Sent: 17 November 2011 09:00
To: Planning
Subject: Salisbury Square S6/2011/1994

Comments from [Redacted] at 33 Park Meadow AL9 5HA

PARKING	
Public:	65
Job centre:	31
Existing private:	13
Grand total:	109

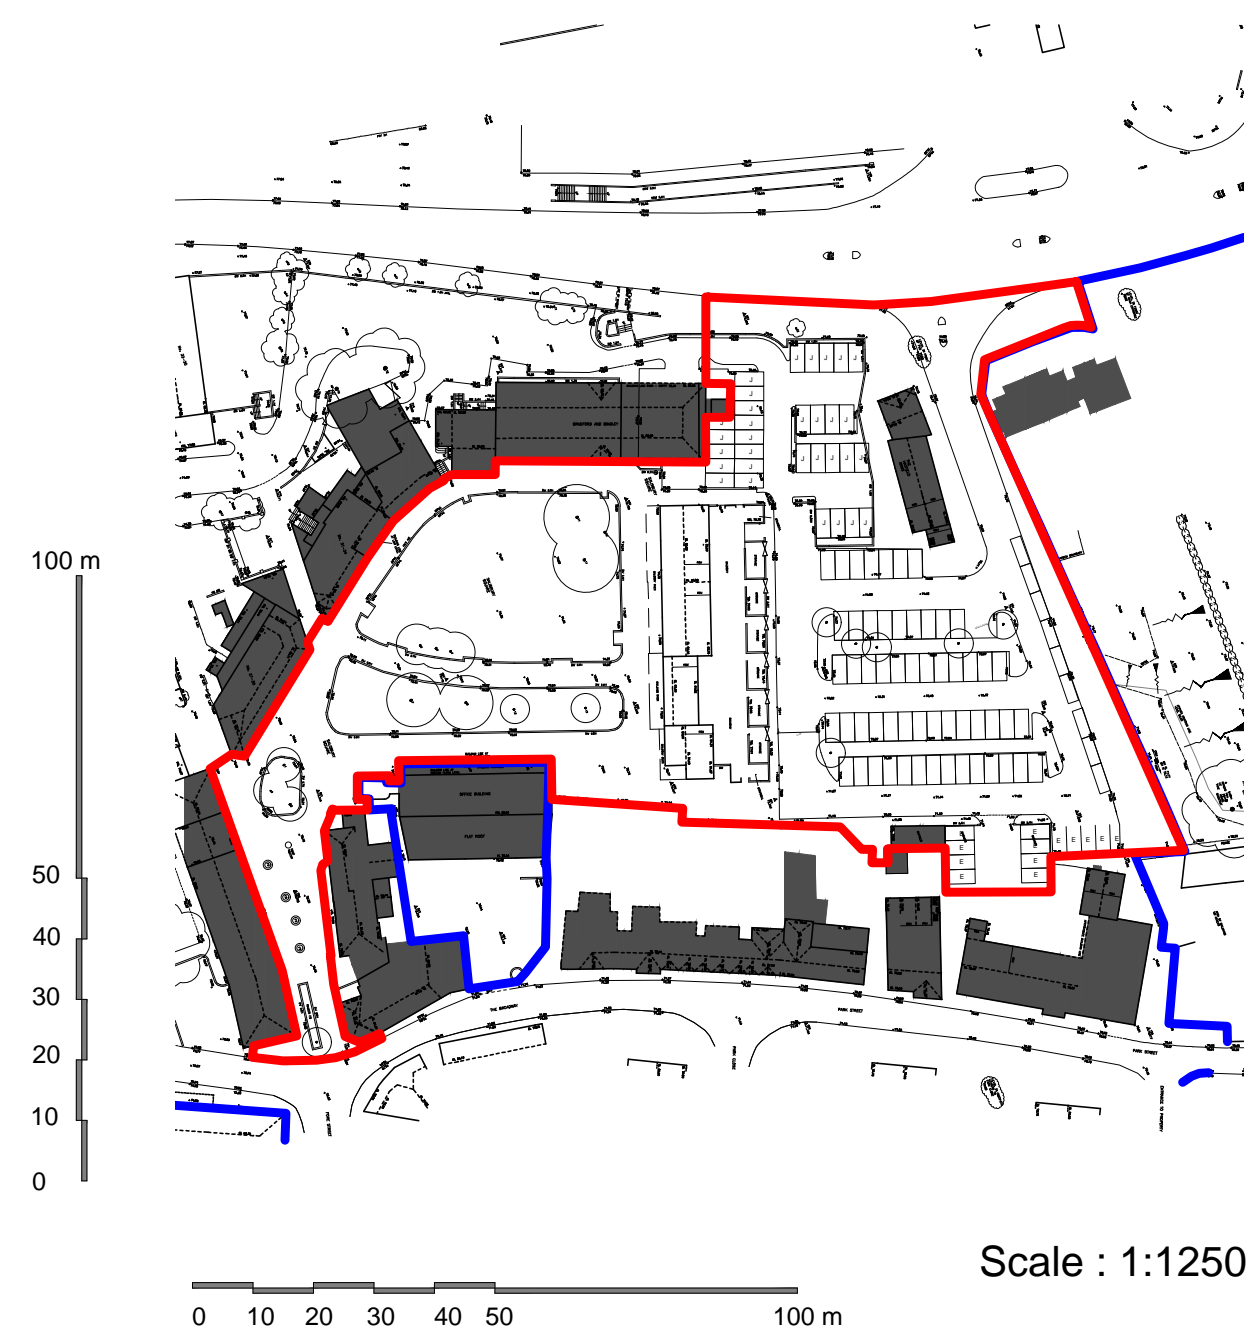
2. The Jobcentre has approximately 37 parking spaces: 32 within the area of the development. How many people work in the Jobcentre, and do they need that many parking spaces? Also, 12 of the parking spaces provided for the Jobcentre are situated in exactly the place where users of the largest retail unit would want to park.
